HYDROLOGY SECTION PROJ. NO. H-22 DATE: 2/9/84

CONFERENCE RECAP

SUBJECT: Lots 14, B&C, 2A, B&C Brantwood Hills
Block 27-A

RE: H22 - D39 Lots 1A, 1B, 1C, 2A, 2B, 2C Block 27A
Brentwood Hills

Don Butts
Revised 4/17/84
2015

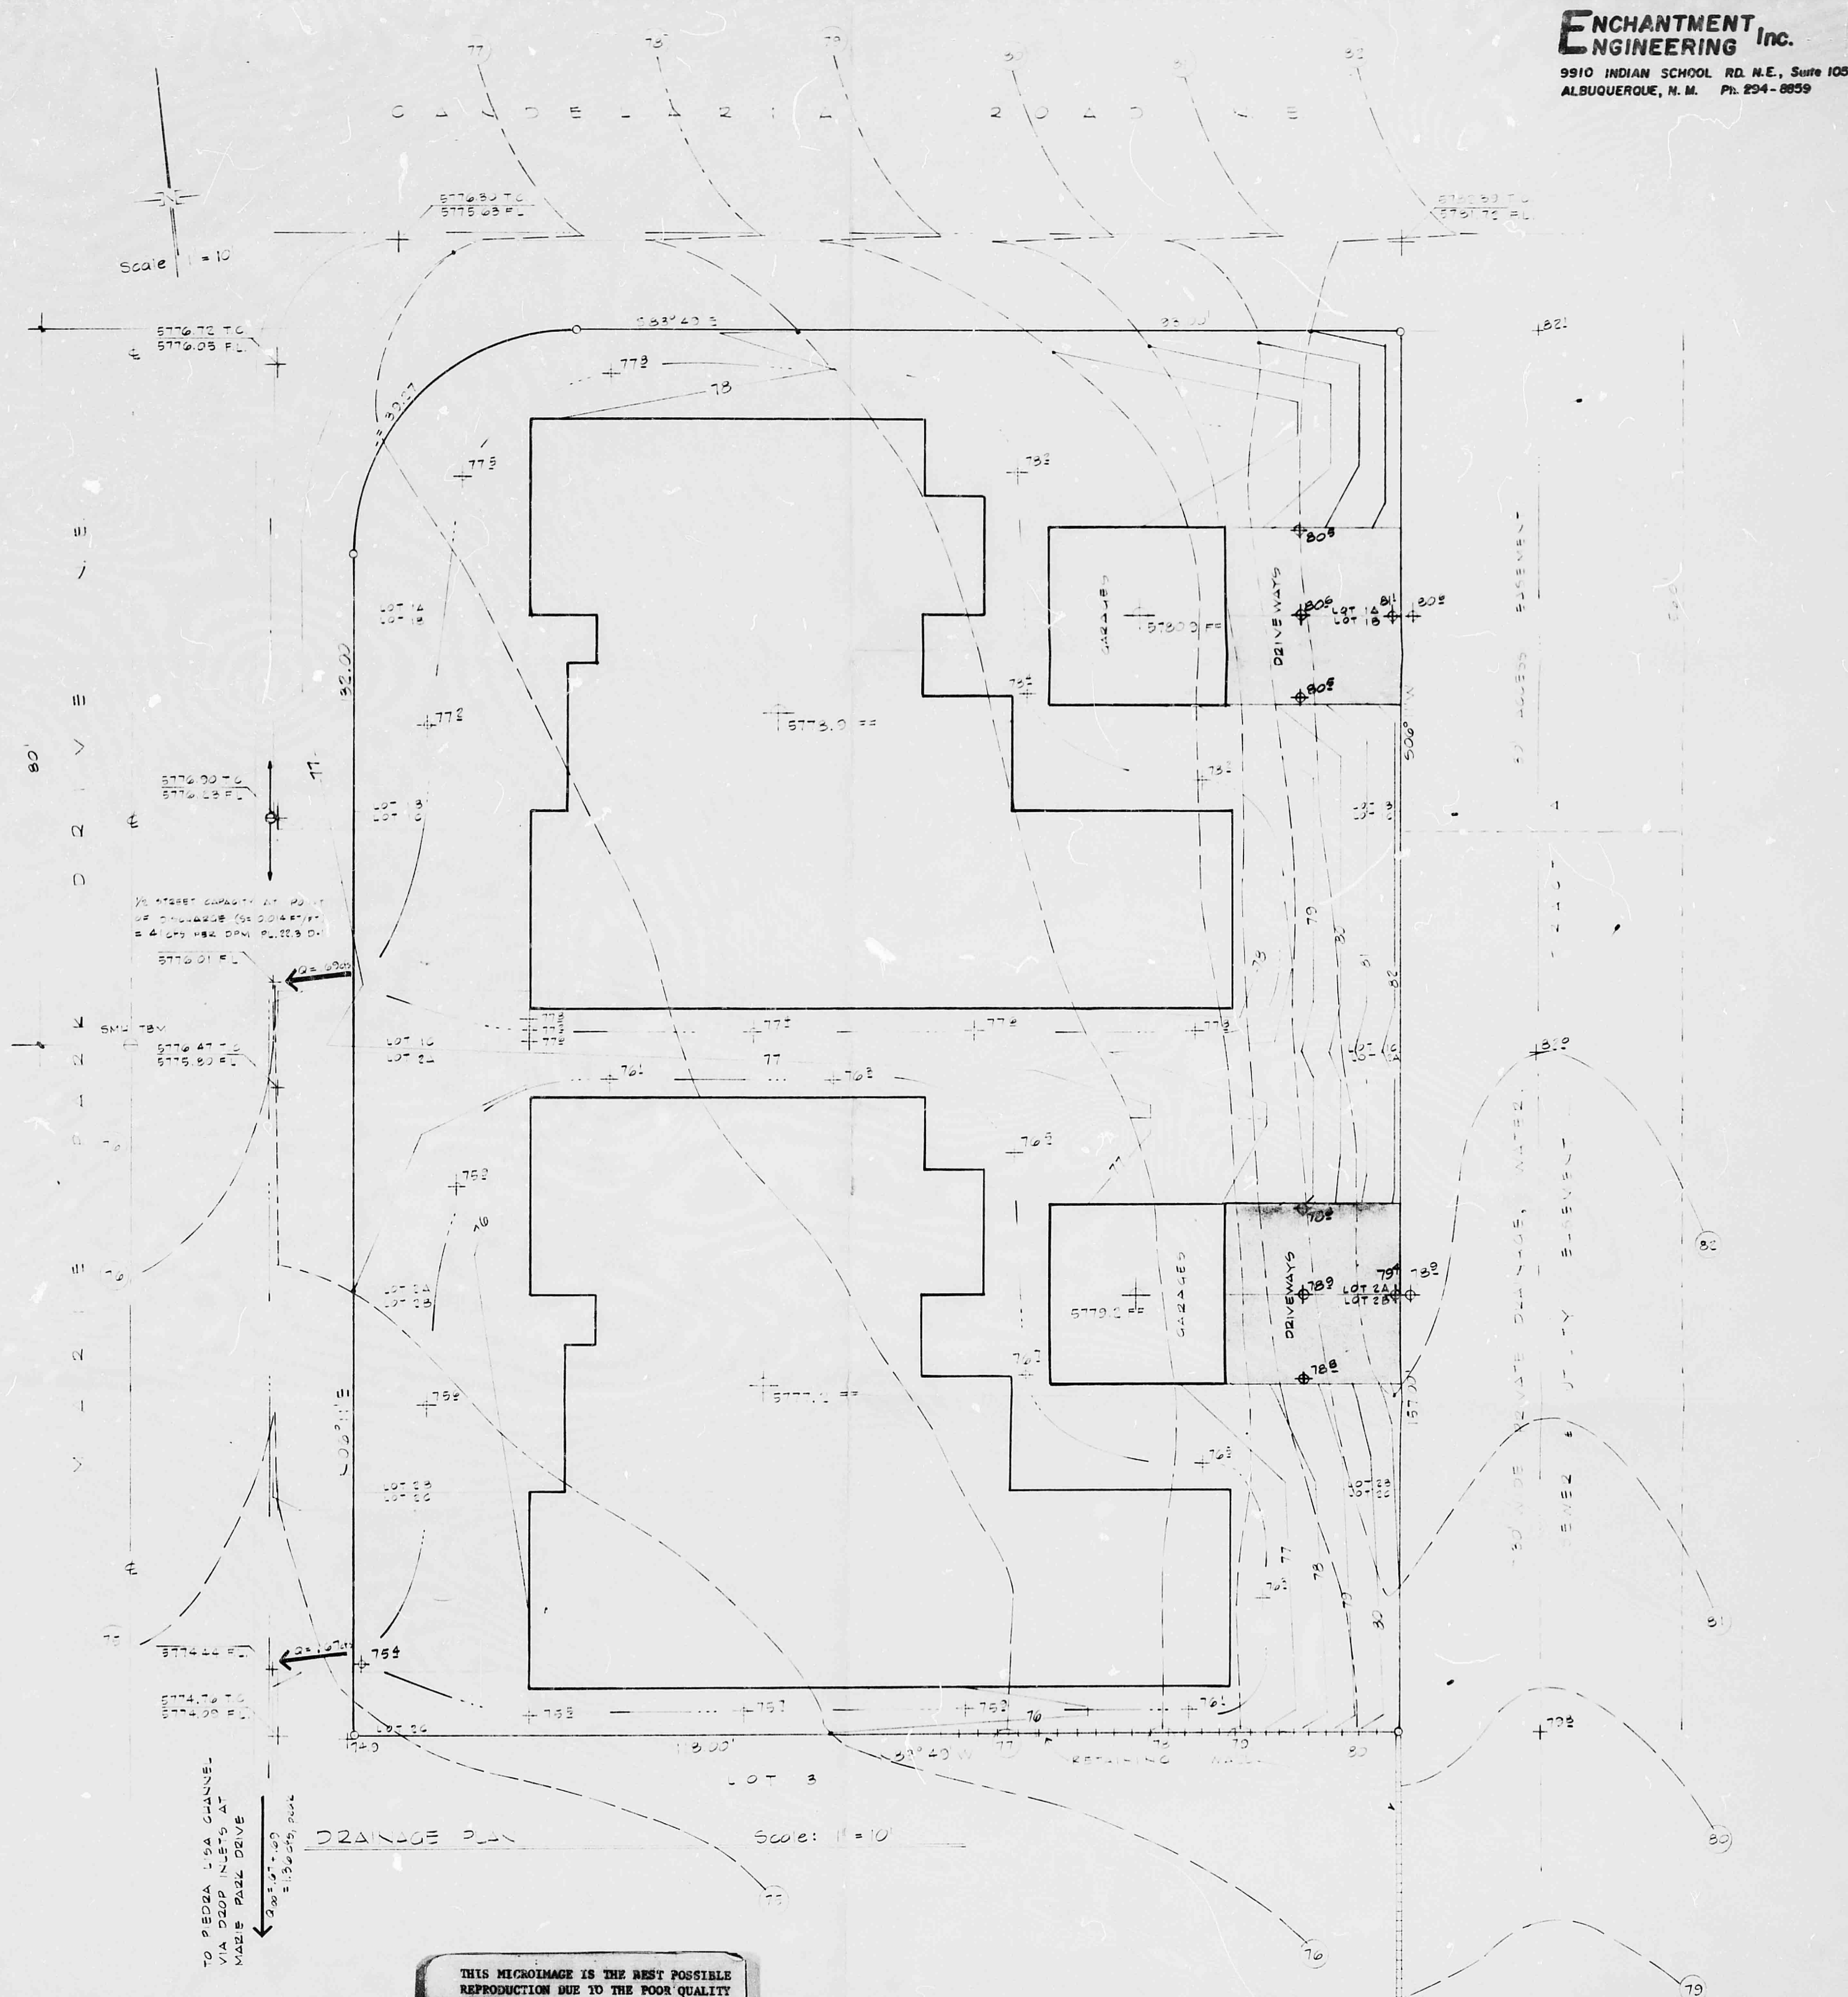
FINDINGS: ① Drainage Plan per DPM
② Discharge to Public R/W through
driveways. Analysis required to justify
downstream capacity exists - Street flow
& where the outfalls.
③ Drainage Covenant required for
drainage across lot lines.
④ Erosion Control Plan required for
period of construction.

Consider this approval of the drainage and grading plan for the afore-mentioned site. Please note, however, that prior to issuance of a building permit a signed and recorded copy of the homeowners agreement and easements must have been received by this office. Also amend Item 8 to refer to "... the drainage plan filed with the City Engineer's Office dated April 17, 1984, file H22-039."

1. Easement for crossing lotlines
2. Discussion as to where the discharged flows go.
3. Clarifications as to what the detached building is and how it interfaces with the adjacent property.
